Erection of a single storey rear extension and alterations.

Brook House 44 Barrack Lane Aldwick PO20 4DB

**Erection of a single storey rear extension and alterations.
Brook House 44 Barrack Lane Aldwick**

**Our Ref: AW/195/11/
Your Ref:**

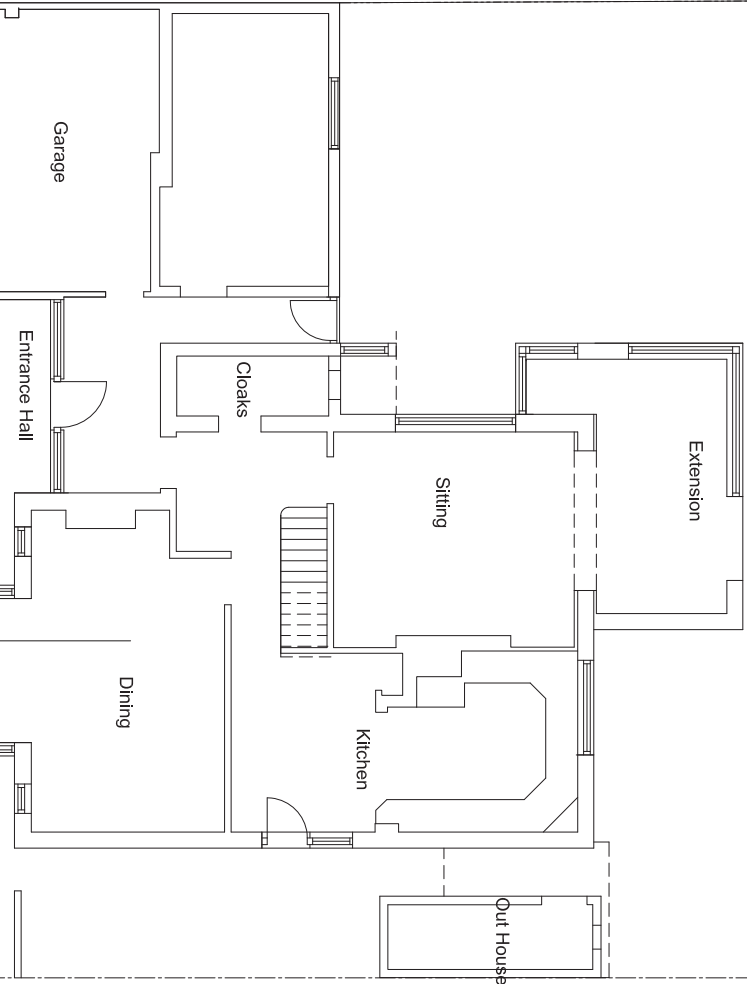
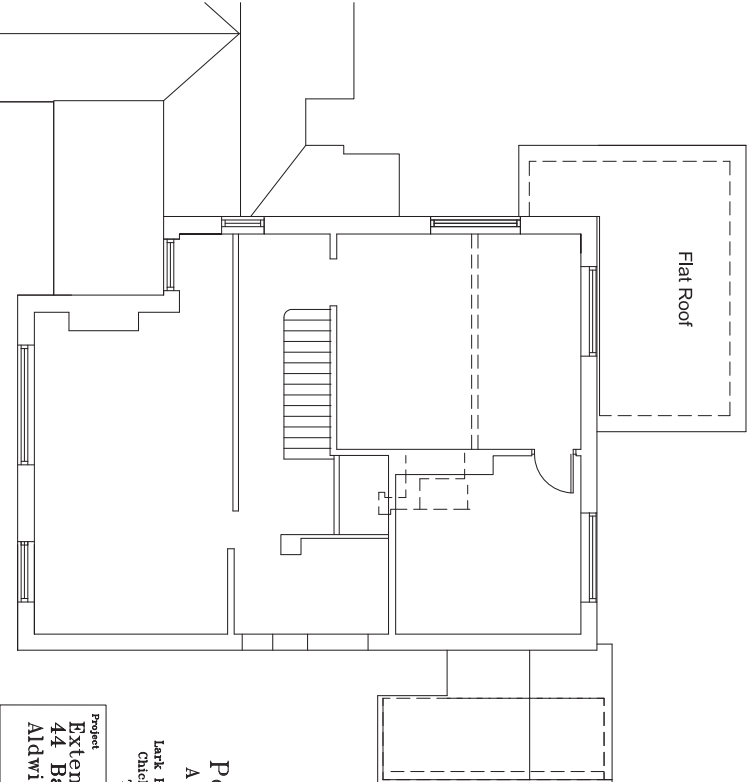
The Location and Block plans do not accord with the existing Floor plan (the garage is attached on the floor plan and detached on the location and block plans).
Please submit 1 electronic or 3 paper copies of an amended location plan to include the existing link to the garage and an amended block plan at scale 1:500 to include existing and proposed highlighted extensions in accordance with the guidance notes available on our website detailed below (click on National List).
